CITY OF PORTLAND

December 12, 1996

RE: 168 Curtis Rd.

Your application to construct a 22' x 36' foundation been reviewed and a permit is herewith issued subject to the following requirements. This permit does not excuse the applicant from meeting applicable State and Federal laws.

TITLE: SCHEMATIC
GRADING

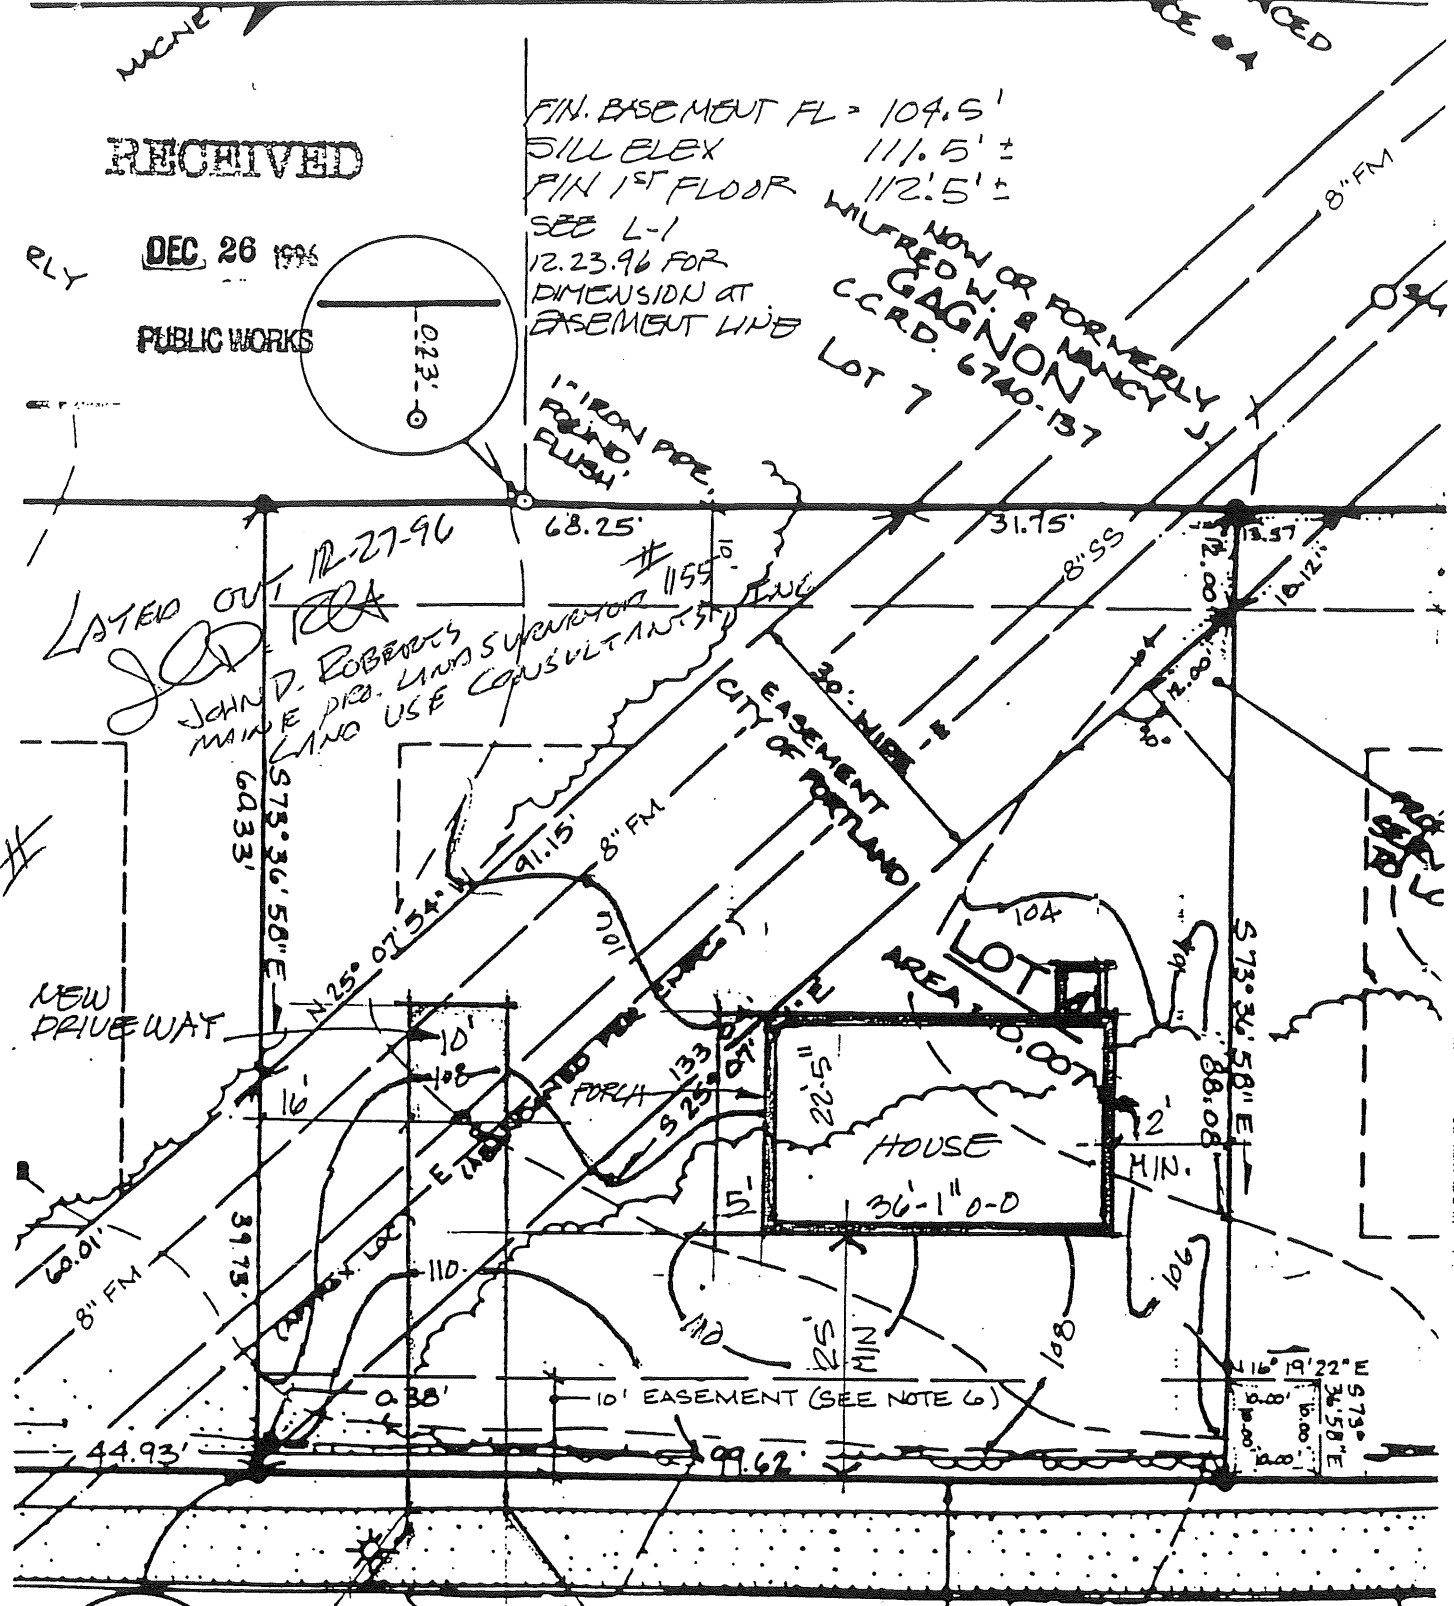
The Building Permit application does not adequately address the issue of regrading of the site necessary in order to construct the foundation and its impact on the adjacent landowners with respect to drainage concerns. As indicated on the plan submitted with the Building Permit application, the finish floor of the basement is proposed to be at El. 104" - 4" whereas the proposed grade in the northwest corner of the foundation is at approximately 105' - 6". The top of the basement walls are at approximately El. 111' per the submitted plan. The proposed foundation walls are to be 8' high on the 10" wall footing. This means that the bottom of footing is at El. 102' - 2". In order to get below frost, which is at 4 feet below grade, the foundation must be below El 101' - 6" here or the existing grade must be raised more than proposed thereby creating drainage questions.

Because of its affects on the abutting landowners, we feel it is appropriate to have the revised plans reviewed prior to the issuance of the Building Permit and not after construction has started.
